EPC STORMWATER REVIEW COMMENTS
IN ORANGE BOXES WITH BLACK TEXT

MERIDIAN STORAGE

CONSTRUCTION DRAWINGS

CONSTRUCTION DRAWINGS
MERIDIAN STORAGE
MERIDIAN STORAGE, LLC
STATE OF COLORADO
EL PASO COUNTY, FALCON, CO 80931
ADDED FILING NUMBERS
SF-23-XXX
VR239

C0.1
 Sheet 2 of 25

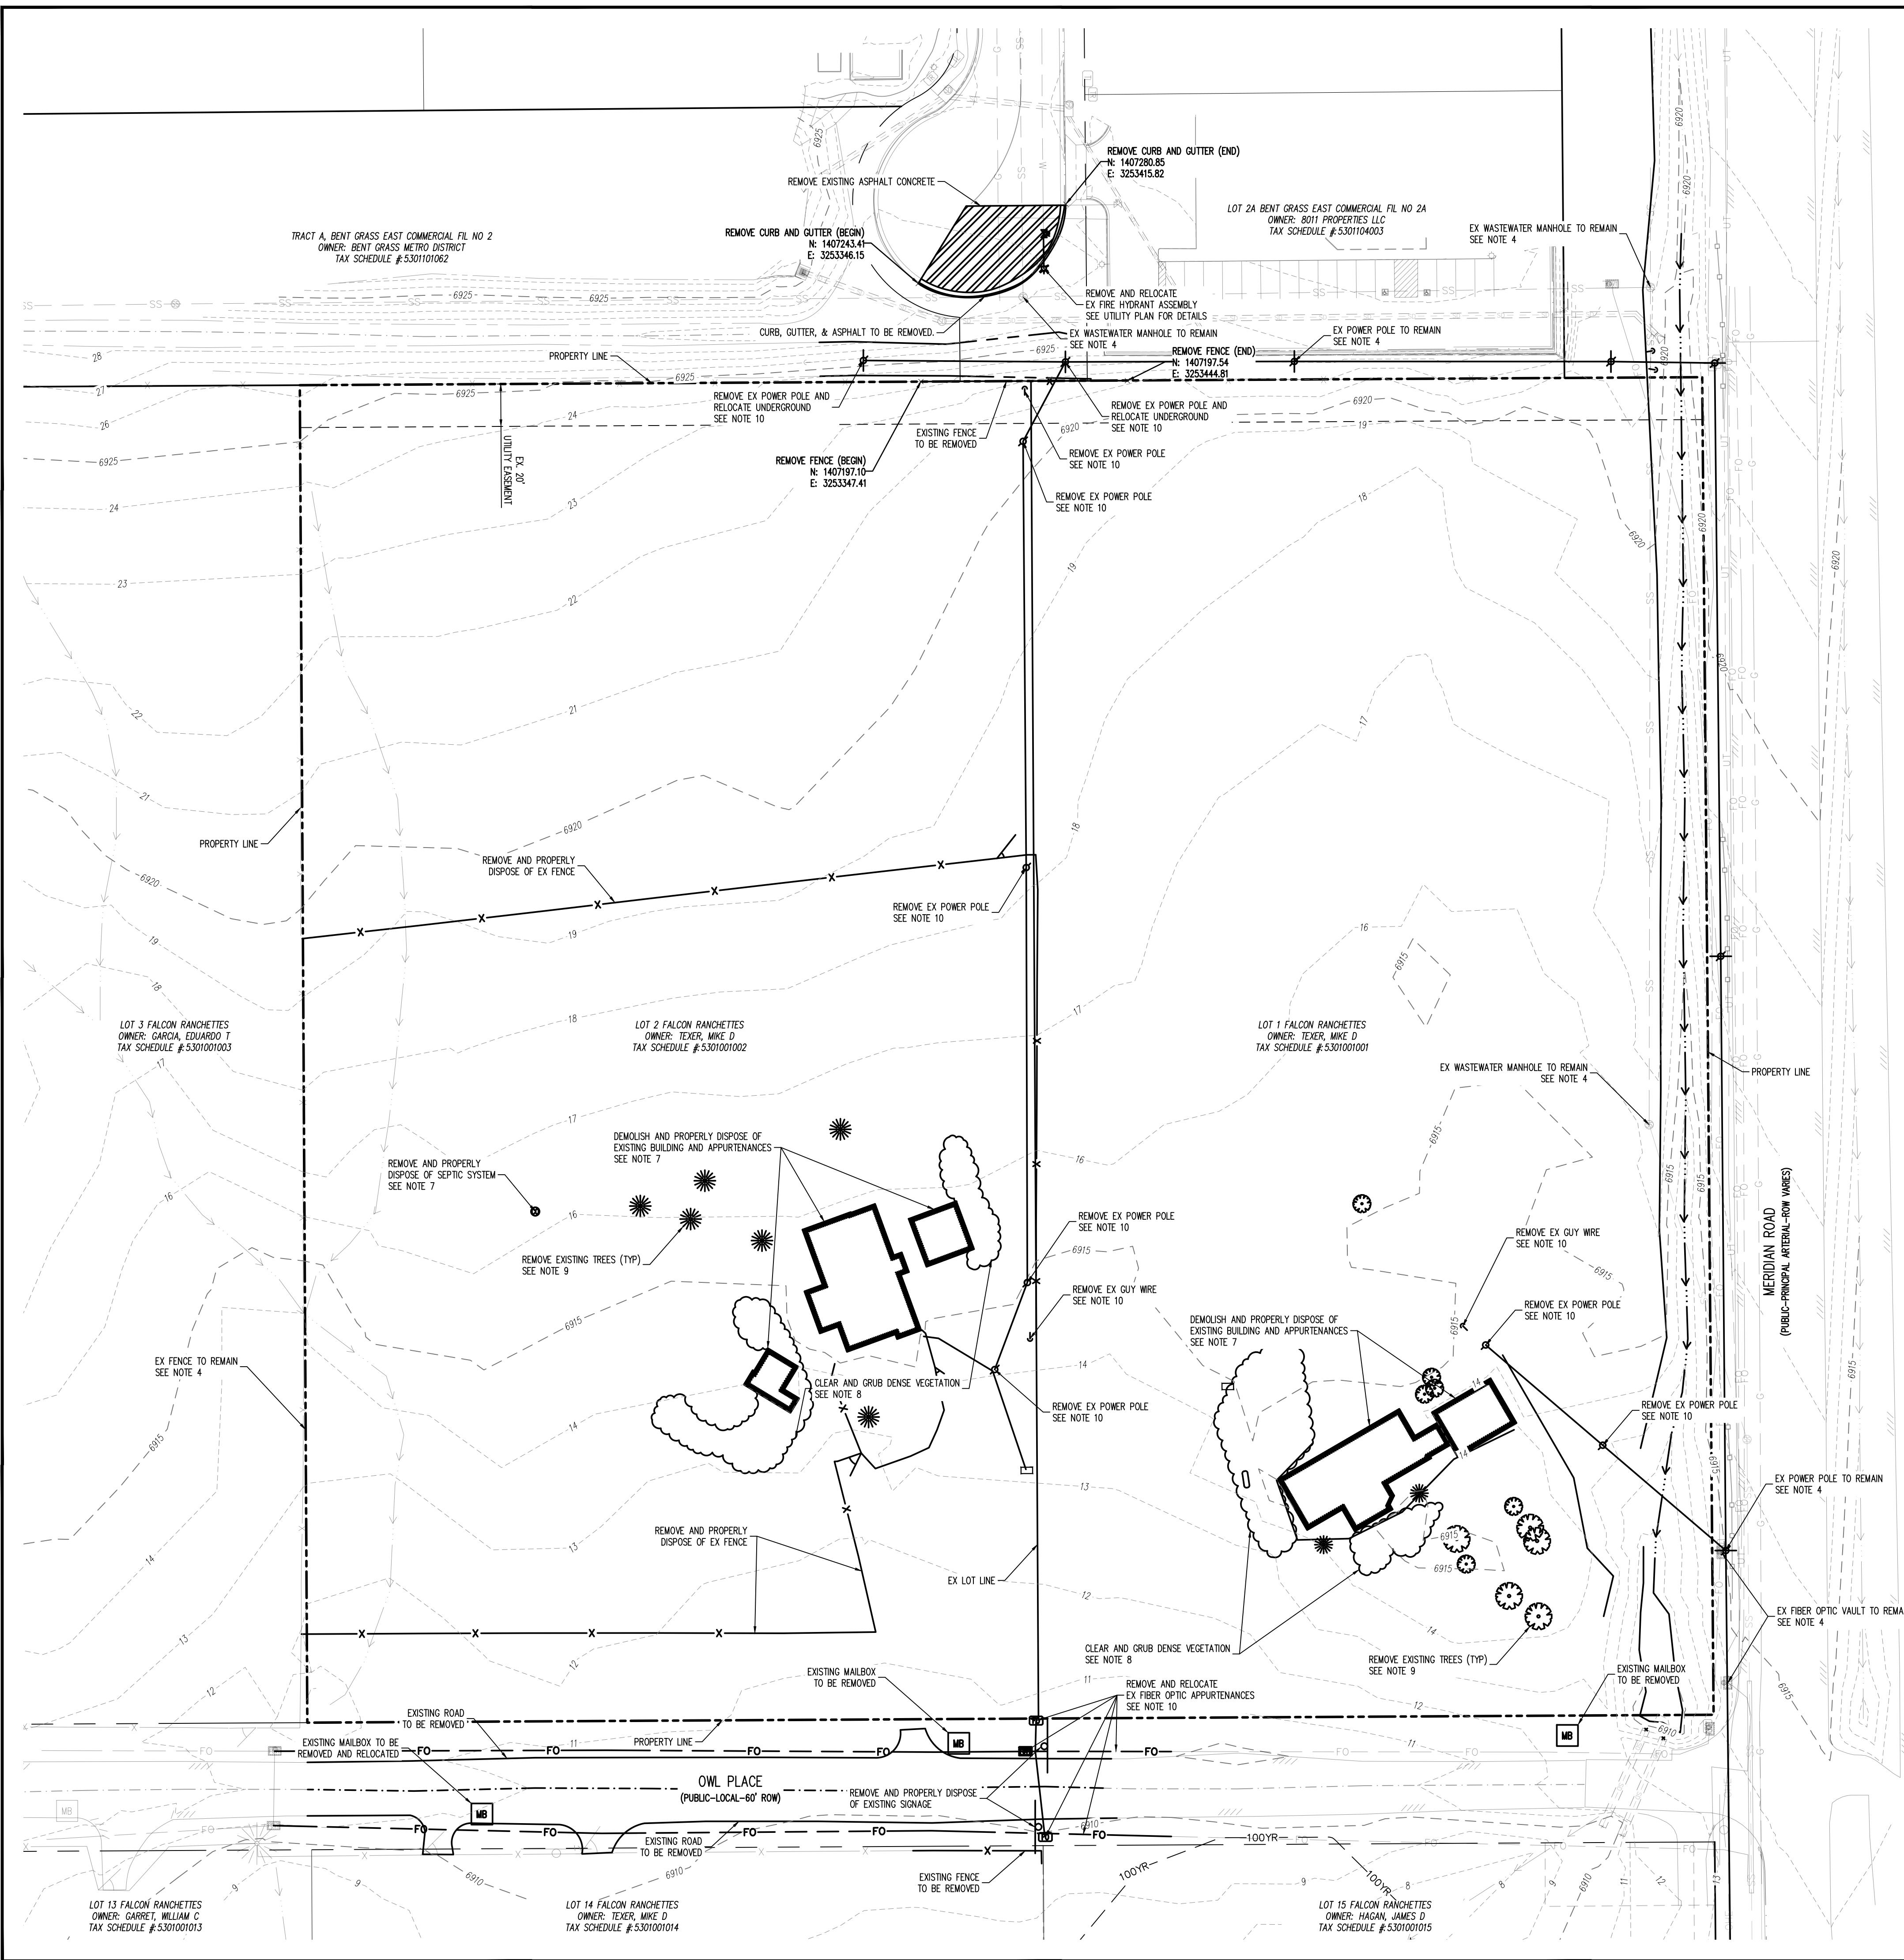
Update Signing and Striping Notes

ADDED SIGNING STRIPING NOTES
